Our Ref: 2001w-SEC-00003-02

28th April 2017

RESPONSE NOTE TO COMMENTS MADE BY THE ARUN DISTRICT COUNCIL (ADC) EHO ON THE PLANNING APPLICATION FOR THE PROPOSED DEVELOPMENT AT CLYMPING

# P14:4899:10 / PLANS & ELEVATIONS

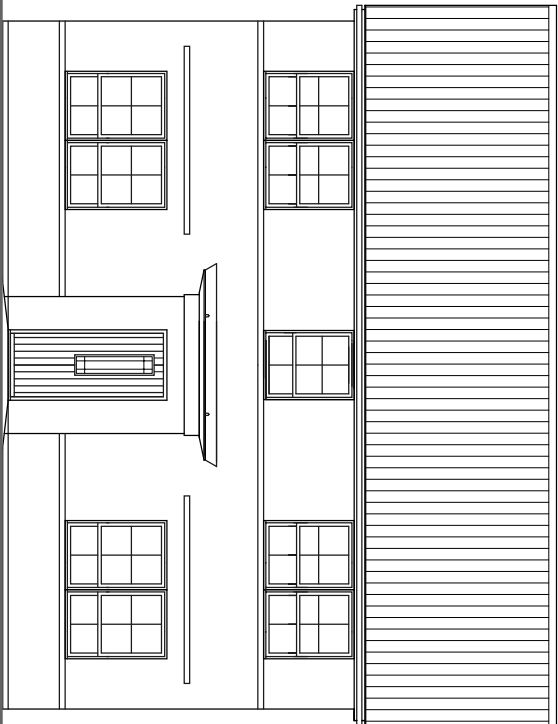
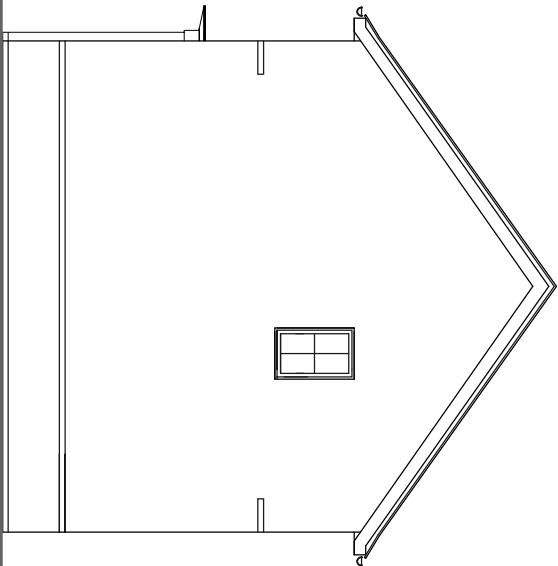
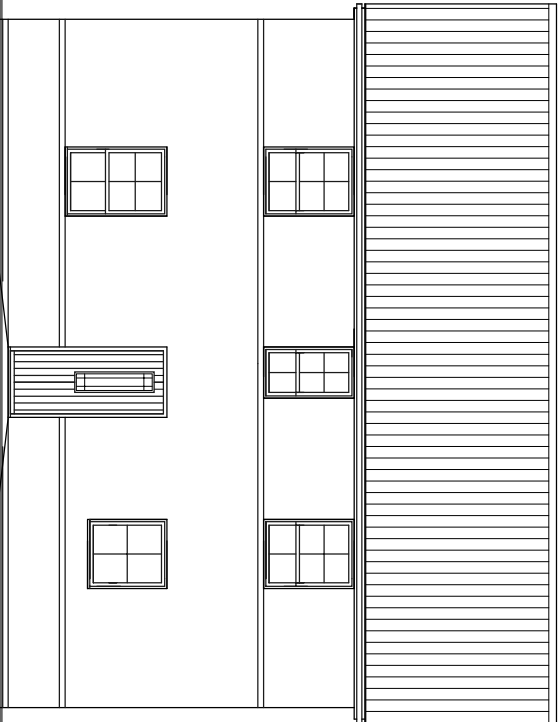
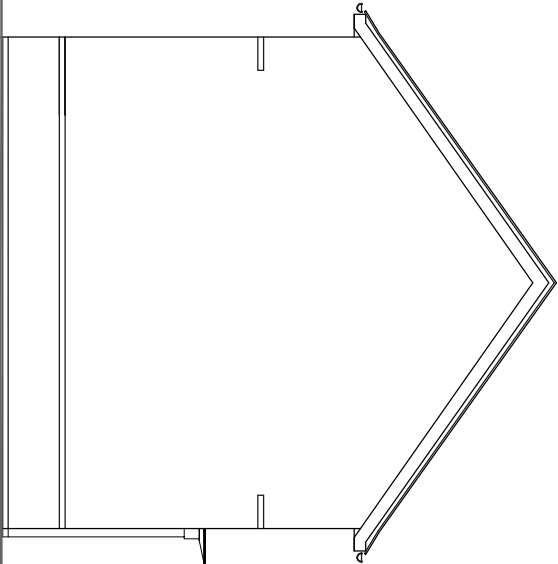
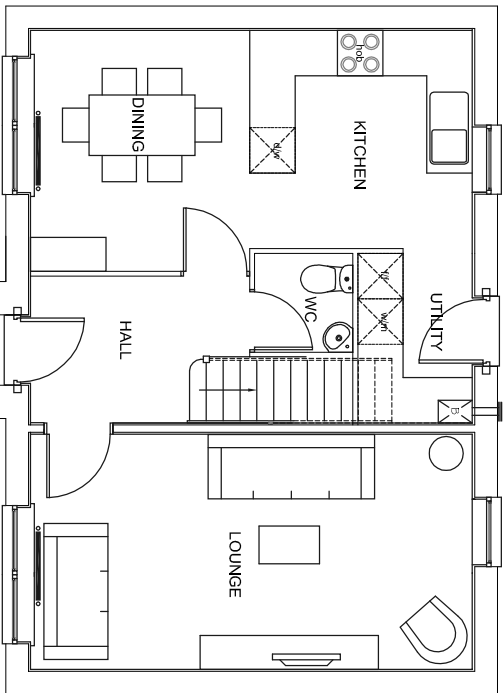
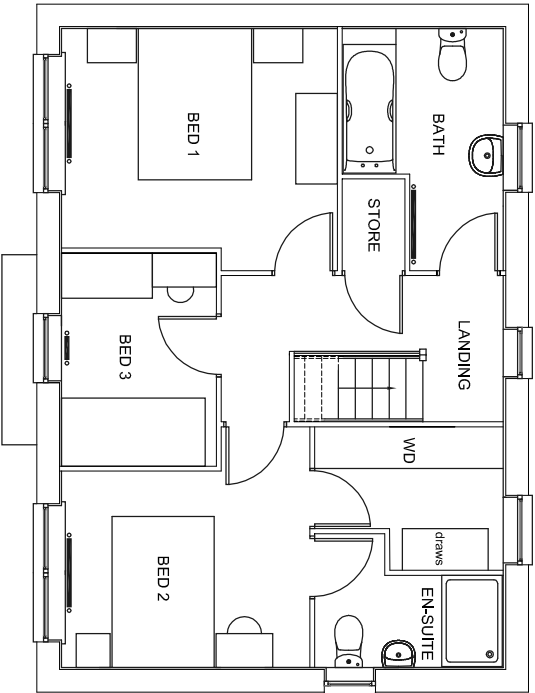
“As stated in my previous email of 28th February, with windows partially open, the 35dB(A) criterion is exceeded by up to +10dB LAeq (16 hour) in the daytime and up to 9 dB LAeq (8 hour) at nighttime. I appreciate that the report suggests mitigation for this including sound attenuating ventilators in the window units, acoustic air bricks in the façade, passive whole house ventilation or mechanical silenced ventilation. However, I would question how realistic it is to expect future residents to not open the windows in a rural environment such as this one. If this application is given permission, I would strongly recommend that a condition requiring acoustic testing of each dwelling prior to first occupation is placed on the permission, to ensure that the stated levels can be reached”.

With regards to expecting residents to not open the windows, the windows on other facades can be opened and the design of the dwellings and their orientation in relation to the A259 and the layout has been adapted to take the noise levels from the A259 into account. The noise contour showing where alternative ventilation and/or alternative layouts may be required is shown in Figure A2. This contour shows the spread of free-field road traffic noise across site, at a height of 4m above ground (representative of 1st floor window height). An illustrative layout of the upper floor bathrooms, corridors and stairwells on the noisier southern and eastern facades and the bedrooms on the quieter facades is shown in Figure A3.

Almost all of the proposed residential properties achieve the guideline value on either the front or rear façade. As such, careful planning of the building layouts should ensure that sensitive rooms have façades that are predicted to achieve the guideline value. A small number of proposed dwellings where both of the main facades are predicted to exceed the internal guideline value of 35 dB are located either in the south east corner of the proposed development.

03 / ACOUSTIC BARRIER ILLUSTRATIVE PROPOSALS

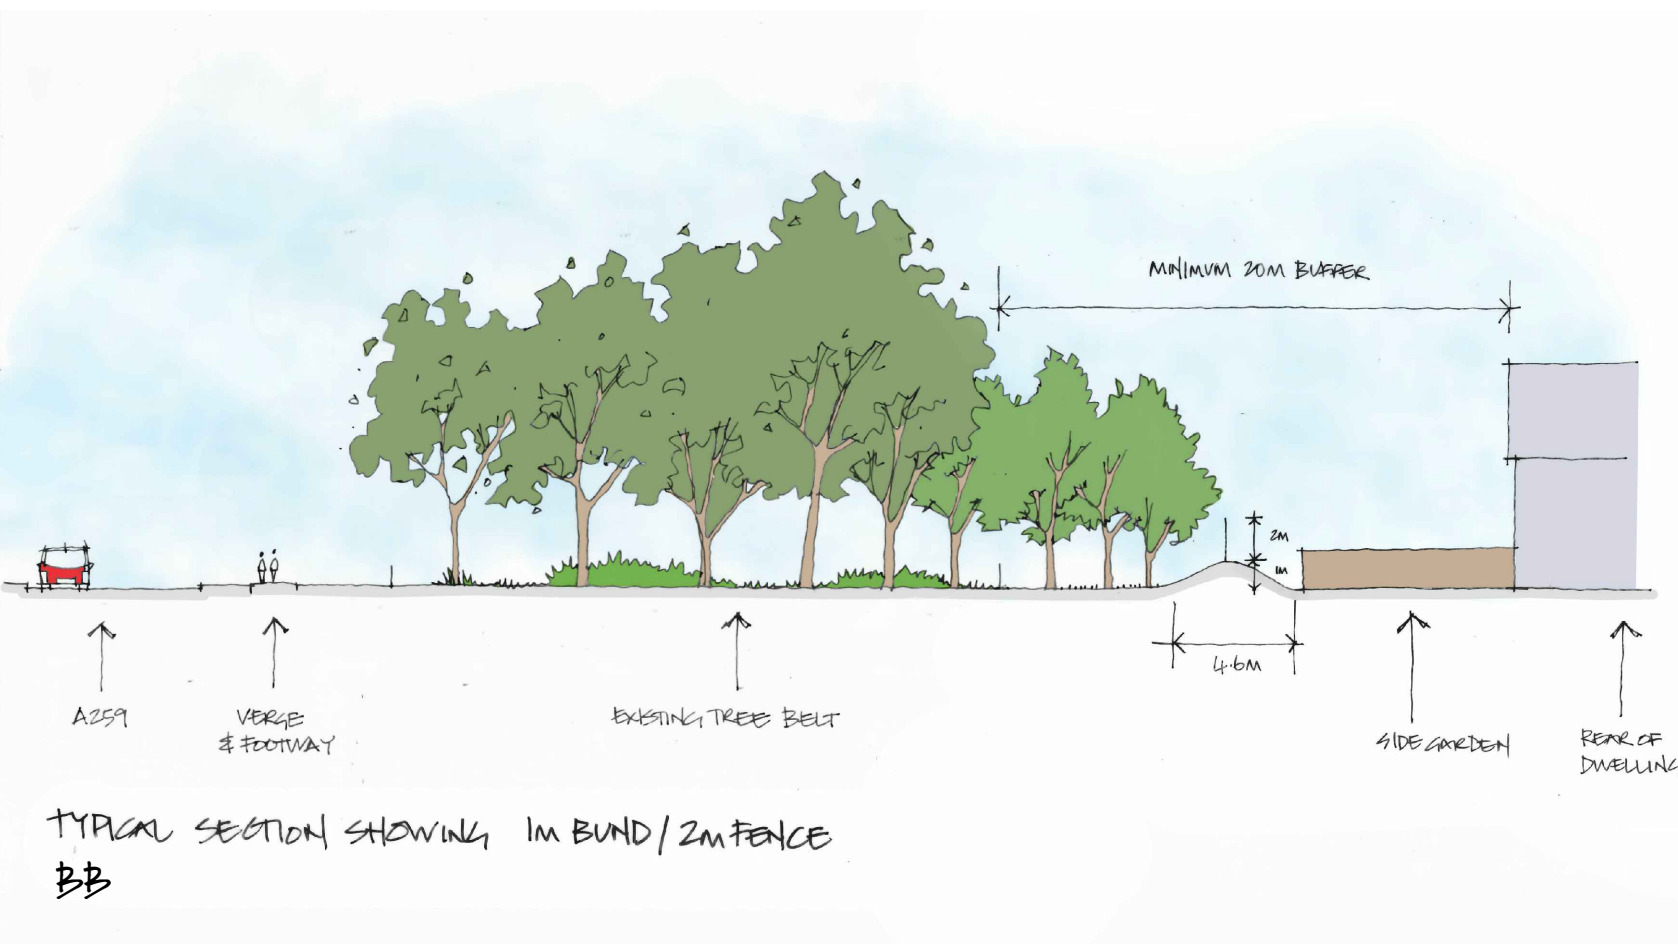
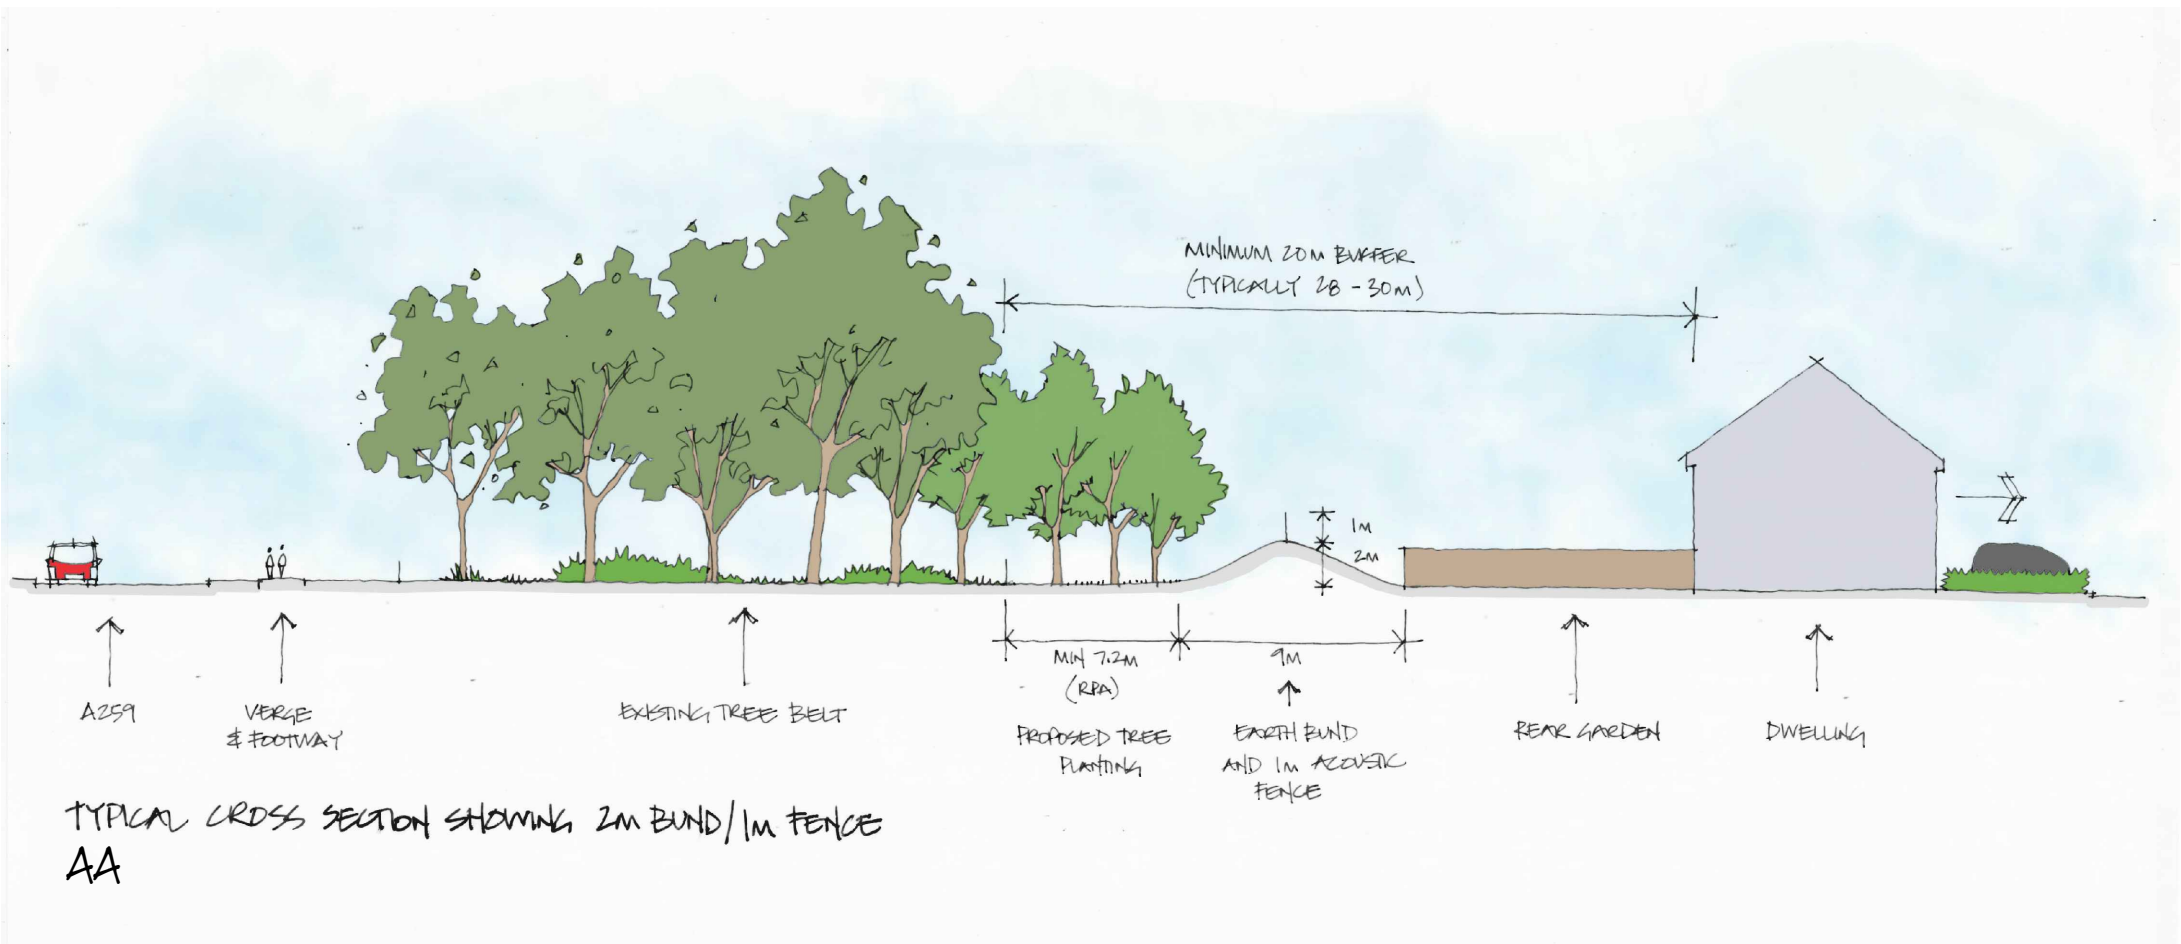
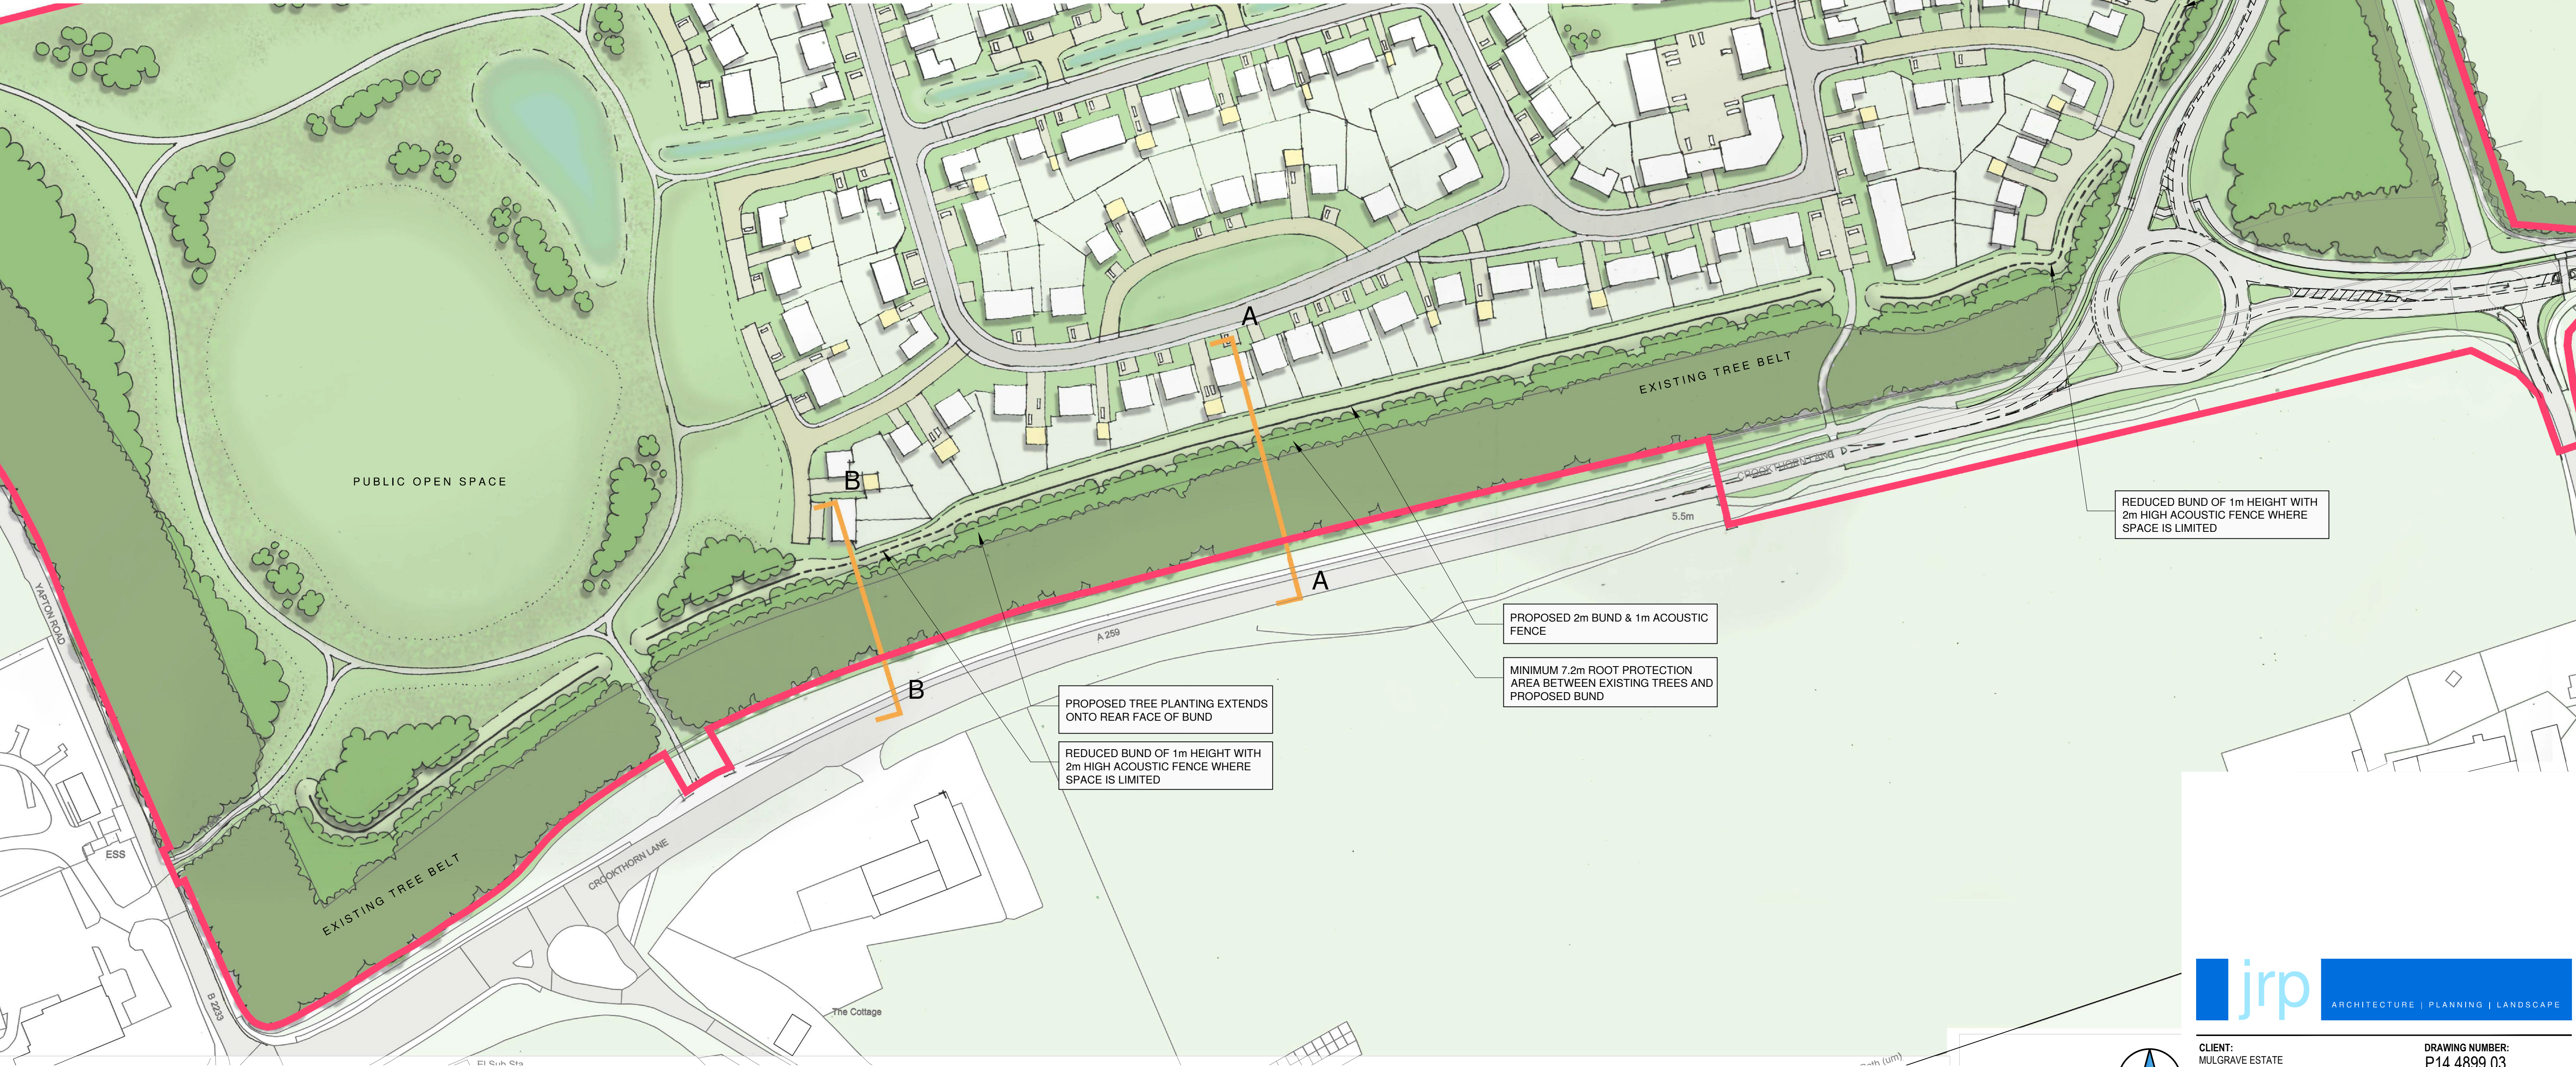
“Please could you ask the applicant to confirm the location and extent of the 1.8m high garden fencing on the boundary of the southernmost proposed properties? Similarly, please could they provide the location and extent of the proposed 2m roadside bund with 1m barrier on top?”

Based on the Masterplan we have assumed that the fence line will be along the southern boundary and the bund to be adjacent to the A259. The illustrative Masterplan, with an overlay of the proposed bund and barrier is shown in Figure A1 of Appendix A of this report.
